From: James Russell
Sent: 14 May 2013 13:29
To: Graeme Thorpe
Subject: EH Comments re Wind turbine planning application - Lower Gazegill Rimington - 3/2012/0954

To:	Planning	From:	Environmental Health
Officer:	Graeme Thorpe	Officer:	James Russell
Reference:	3/2012/0954	Extension No:	4466
Date:	13 th May 2013

Planning Application: 3/2012/0954
Location: Lower Gazegill, Cross Hill Lane, Rimington
Development: Erection of single 20Kw wind turbine

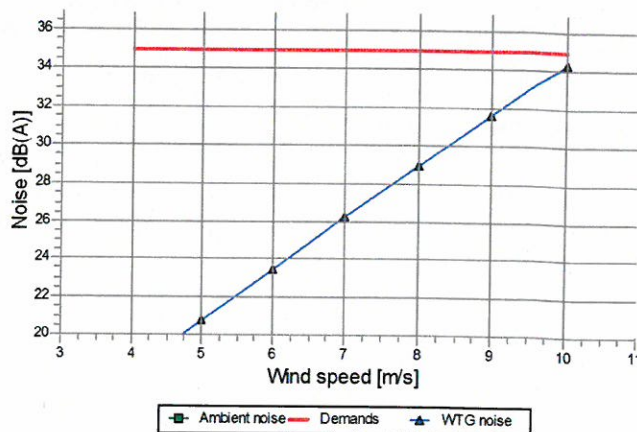
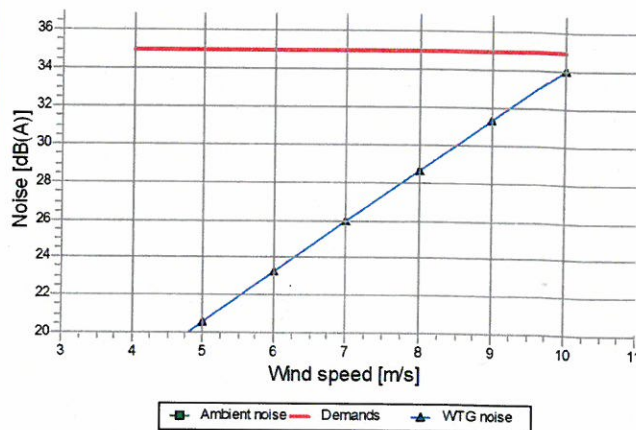
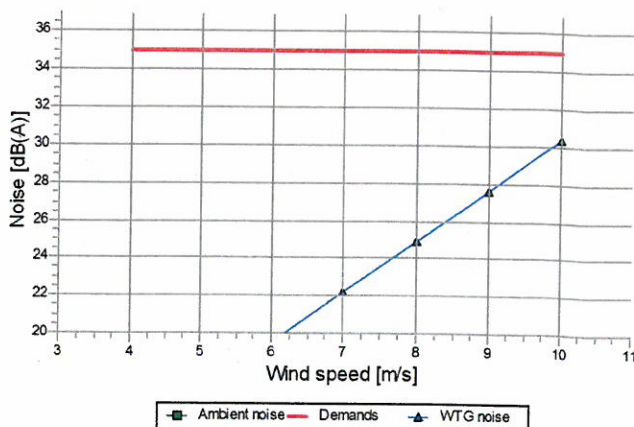
Having reviewed the consultants further Noise Assessment Report I can make the following comments;

The report concludes the turbine meets relevant guidelines, given recent planning inspectorate decisions, it is suggested that the following conditions be attached to any permission granted. ***It should however be noted that nearby residential properties may hear and still be adversely affected by the wind turbine depending on the background noise levels in the area;***

- The noise emissions from the wind turbines shall not exceed a sound pressure level LAeq,T of 35dB at the curtilage of any dwelling lawfully existing at the time of this consent at wind speeds up to and including 8 ms-1 at rotor centre height. Any measurement shall be made at a height of 1.2m and at a minimum distance of 3.5m from any façade or acoustically reflective surface."

- The measurement time period shall be based on BWEA blade length calculation (para 3.4(1) $t=4 \cdot D$ seconds).
Where t = measurement time period in seconds (subject to a minimum period of 10 seconds) D = rotor diameter in metres”
